Date: October 9, 2023
To: Kittitas County Community Development Services
411 Ruby St. Suite 2
Ellensburg, WA 98926

Re: Fowler Creek Guest Ranch (CU-23-00003)

My name is Kathryn Podobnik and I live at 841 FS RD 4517. I am submitting this notice of opposition to the project "Fowler Creek Guest Reach" for consideration.

PROPOSED EMERGENCY INGRESS & EGRESS PLAN MAP - FOWLER CREEK GUEST RANCH

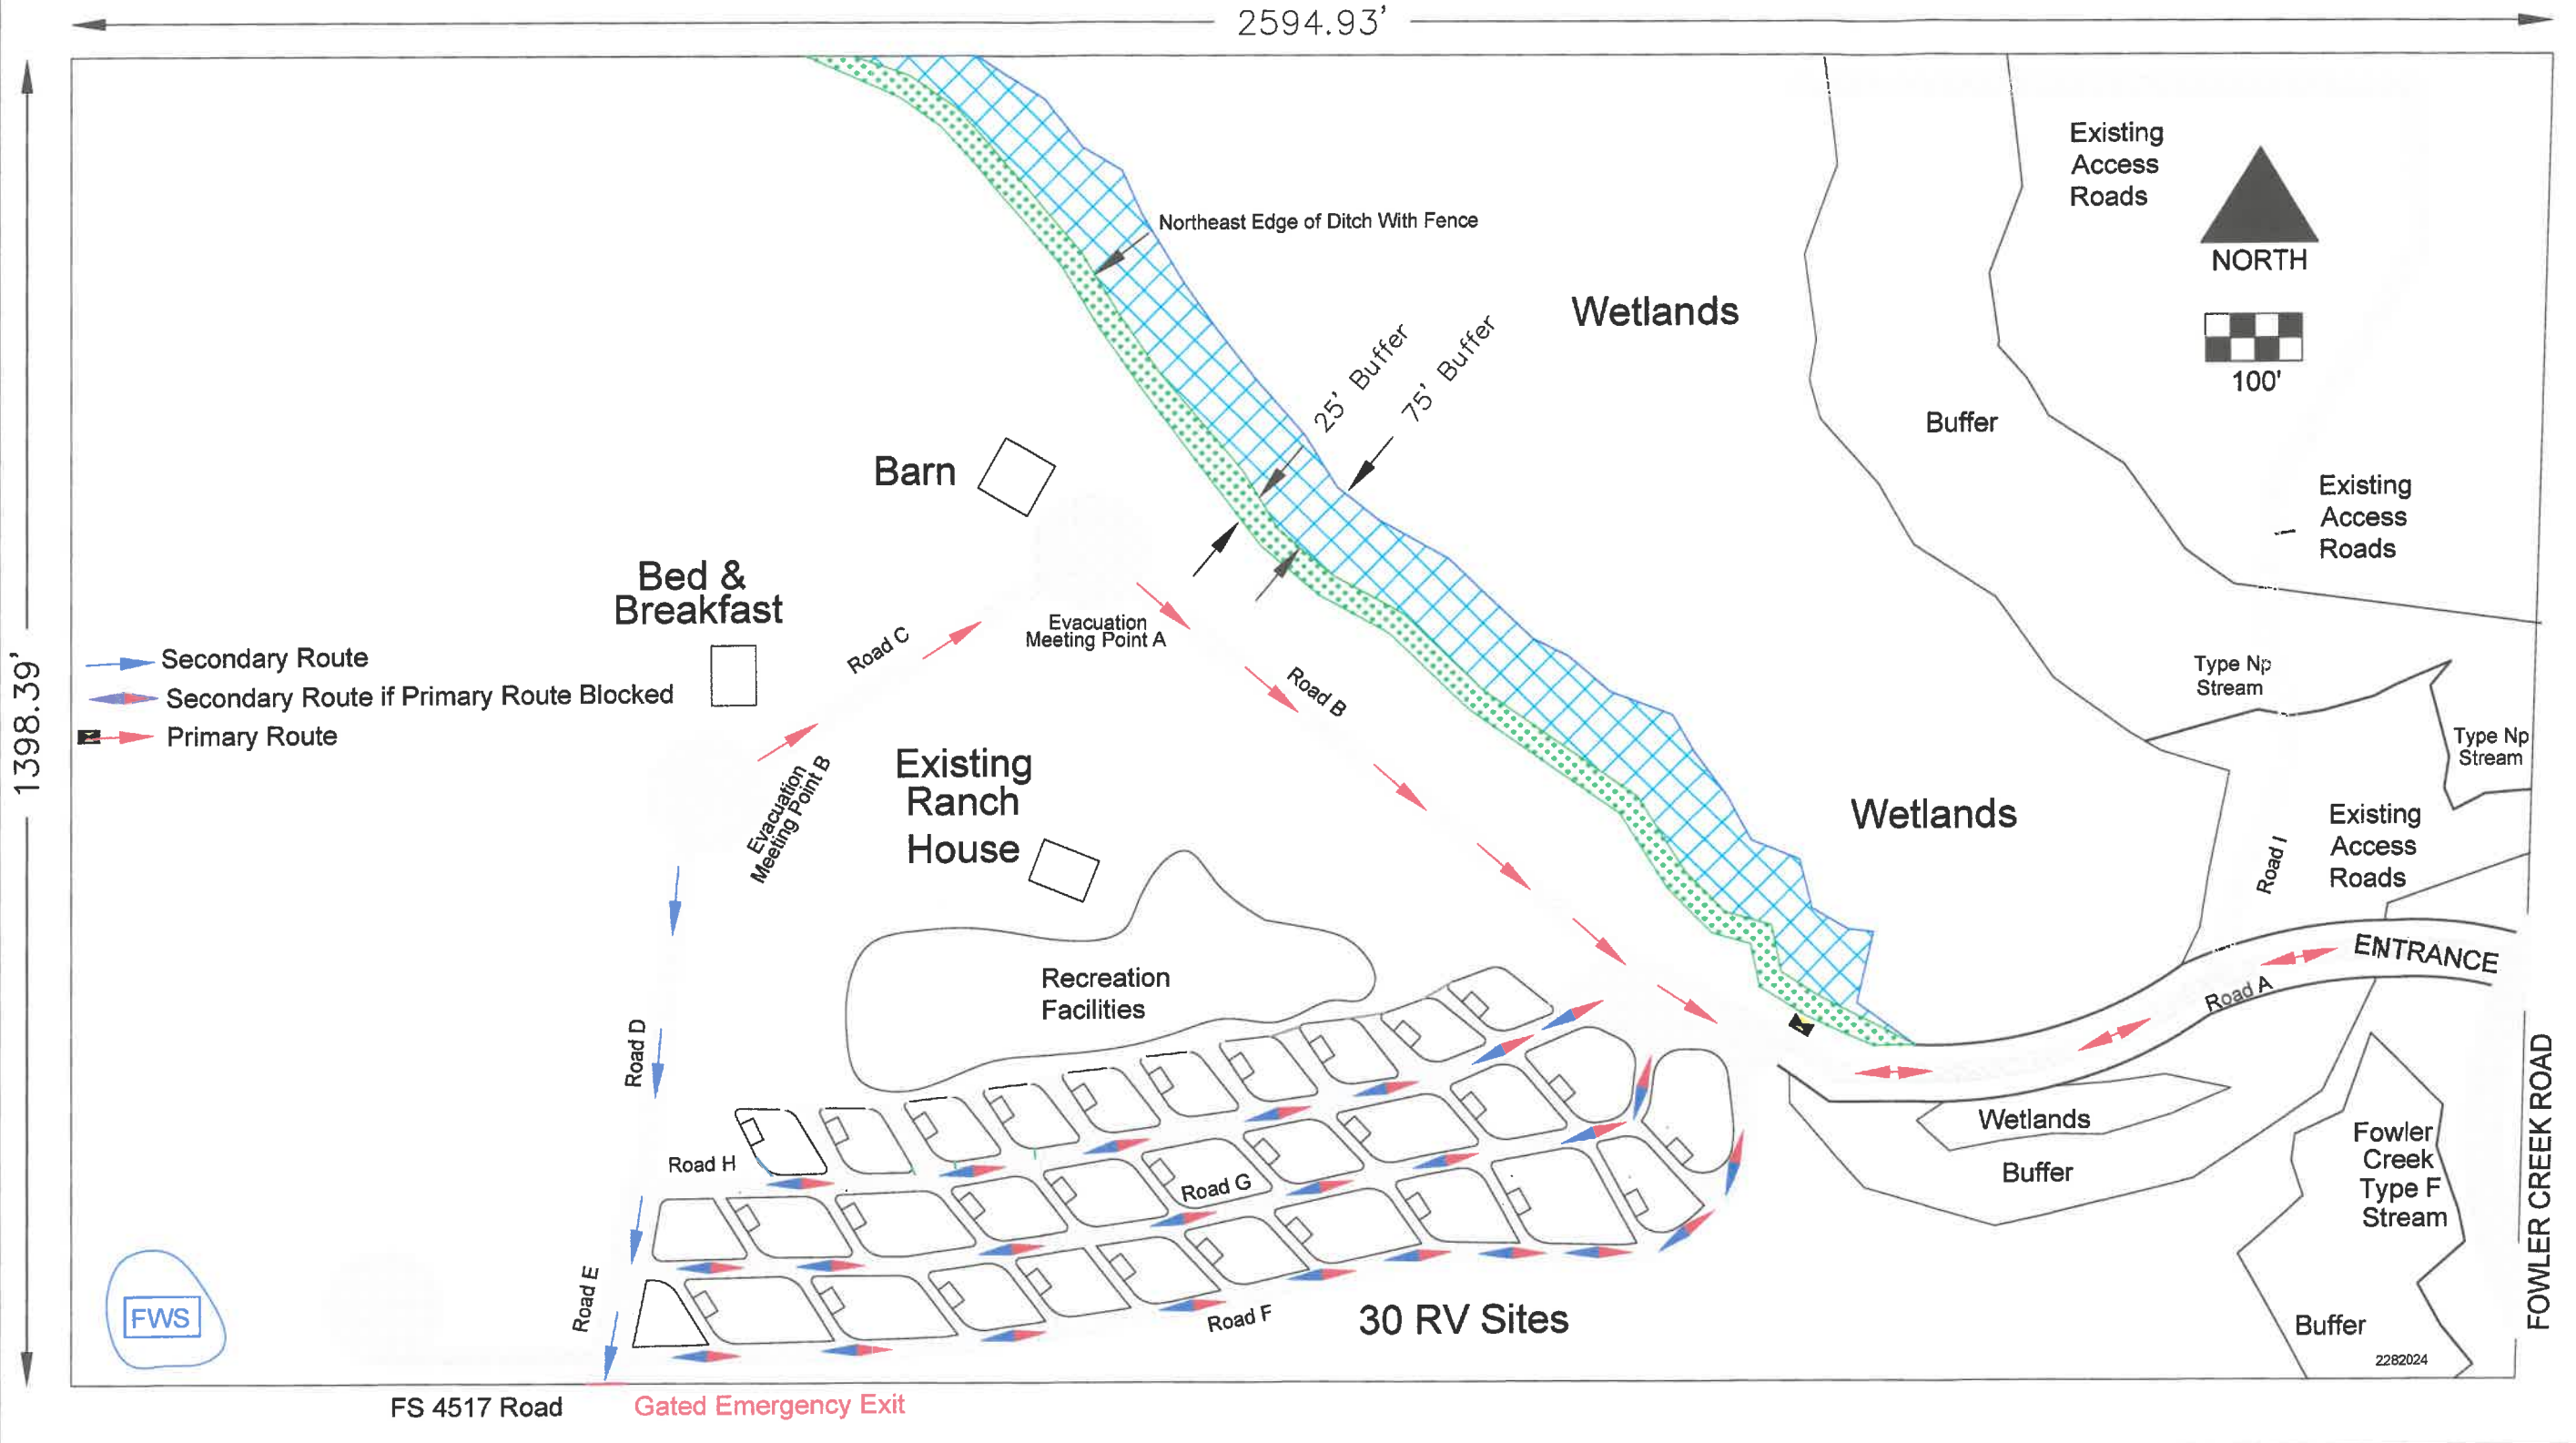
The emergency response, while sufficient to support the estimated <100 residents of the surrounding neighborhood, is not equipped to support the need, timeliness, and size of potential emergencies that a site with 200+ guests could need. In addition, the road defined as an 'Exit' in the plan, falls onto FS RD 4517, a maintenance level 2 road with no provisions for road improvements or upgrades.

Additionally, public services here are limited, Forest Service RD 4517 to Fowler Creek Rd. serves as the only egress in and out for the community. Any sort of congestion or accident can completely halt road access, a potential devastation to life in an emergency. The applicant's traffic review as outlined in Exhibit 12 not only dismisses the existing realities of the roadways, but by a significant matter of scale miscalculates and therefore misrepresents the anticipated level of traffic.

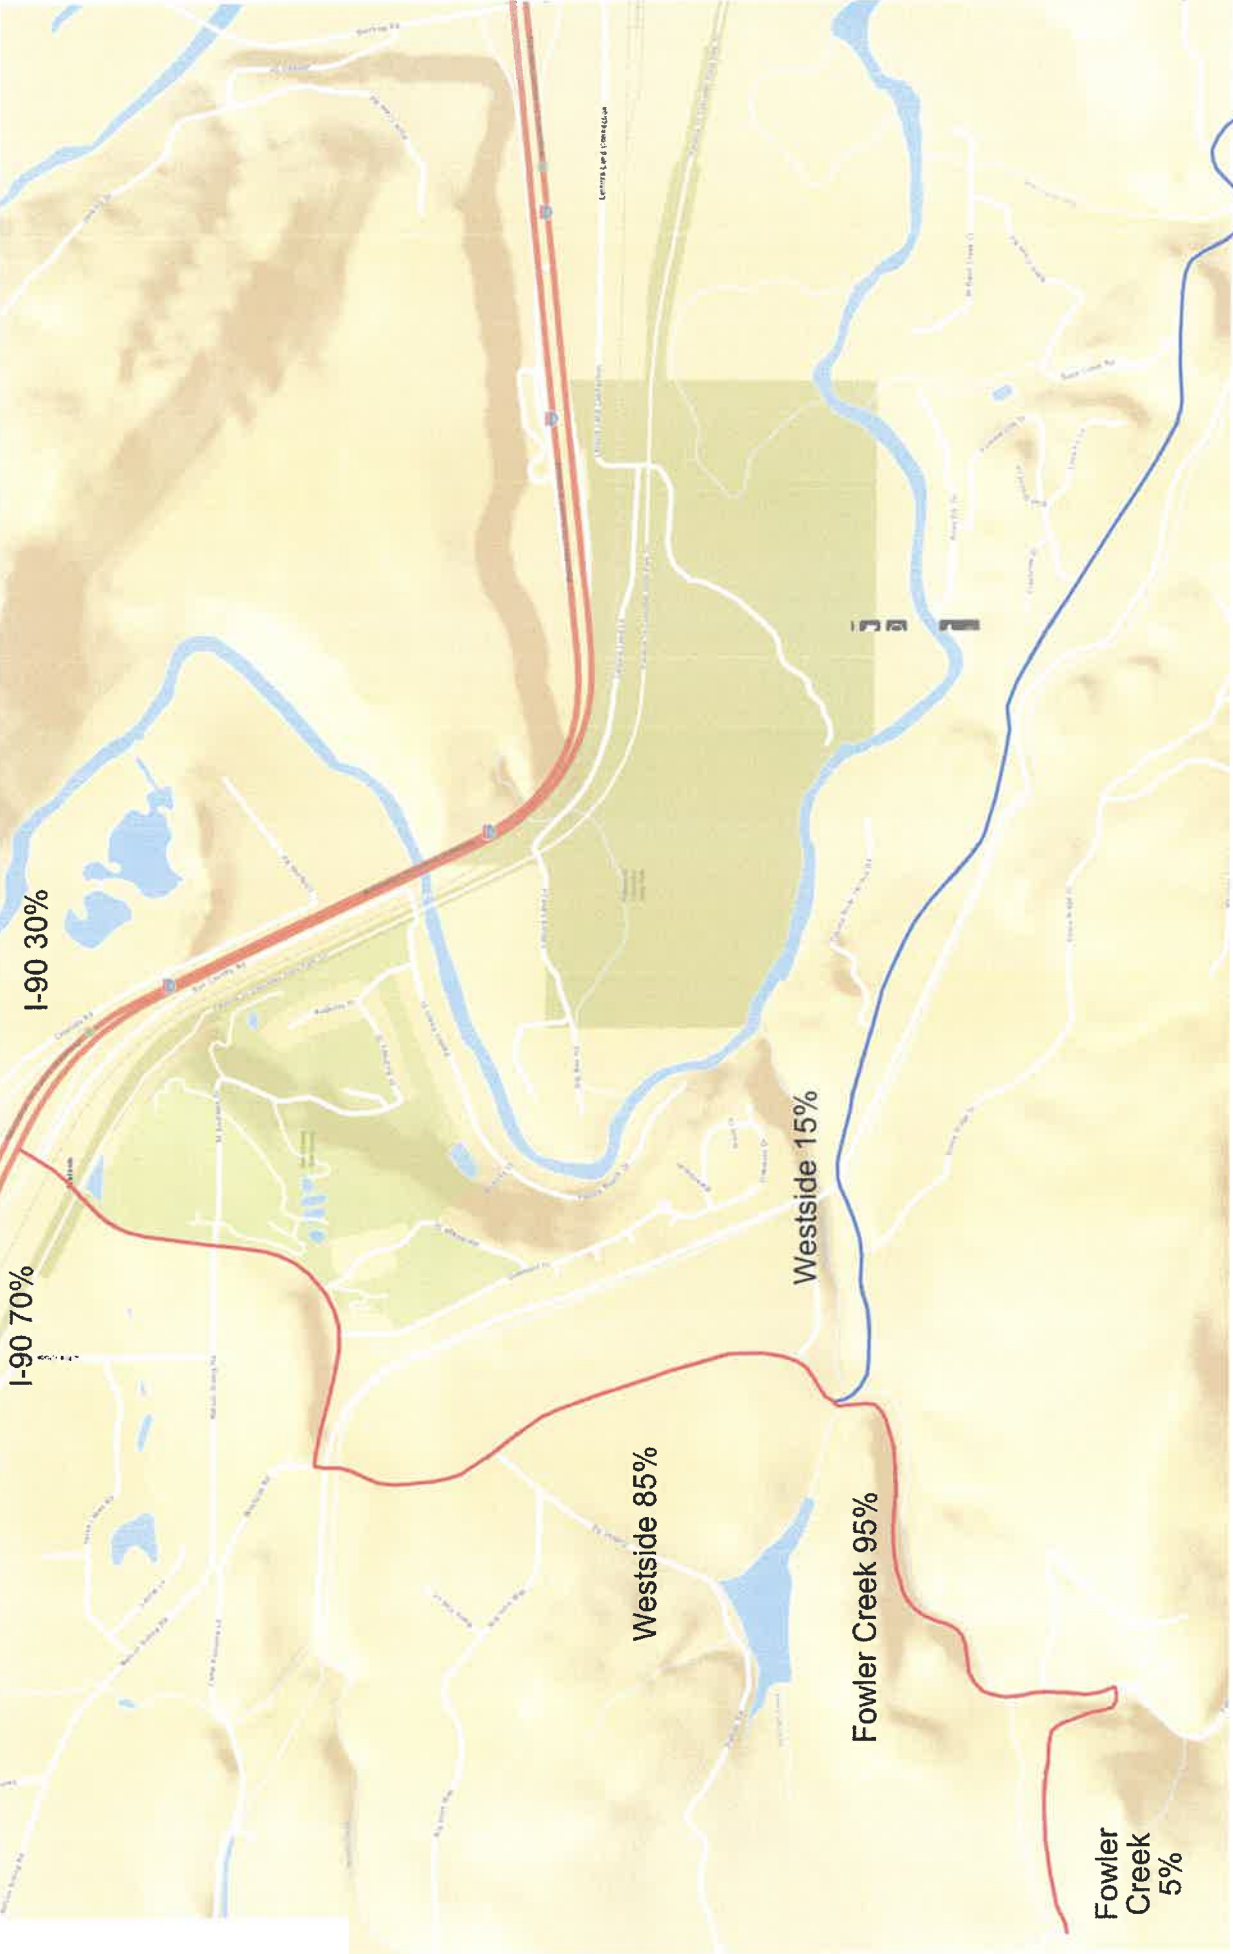
Applicant's Traffic Impact Table from Exhibit 7 is copied below. This table is woefully inaccurate as the applicant utilized Average Daily Trips (ADT) counted at each intersection, but added only expected "Peak Hour ADT" when **TOTAL ADT** should have been used when projecting their overall impact.

Revised Proposed	Fowler Creek Guest Ranch Traffic Impact Table				
	Road and Mile Post	ADT(4)	Projected Guest Ranch ADT(2)	Total with Projected Guest Ranch	Projected Percentage Increase
	Fowler Creek Road MP 0.110	191	217	408	114%

When the applicant states they believe that 85% of the traffic will head West towards I-90, why did only one of the 3 other intersections after Fowler Creek Rd that they evaluated consist only of the 10% they expected to drive East? Intersections to the West are critically important when evaluating true impact

Additionally, applicant's referenced traffic reports account for **weekday traffic only and does not include the not insubstantial existing weekend recreational traffic (ATV's, motorcycles, 4-wheelers) traversing these same roads. It also seems reasonable to project that at least some of these STR sites will be occupied by people wanting close access to areas already under heavy off-road use, thereby also increasing traffic west of the proposed Resort entrance. This traffic increase has not been addressed.**
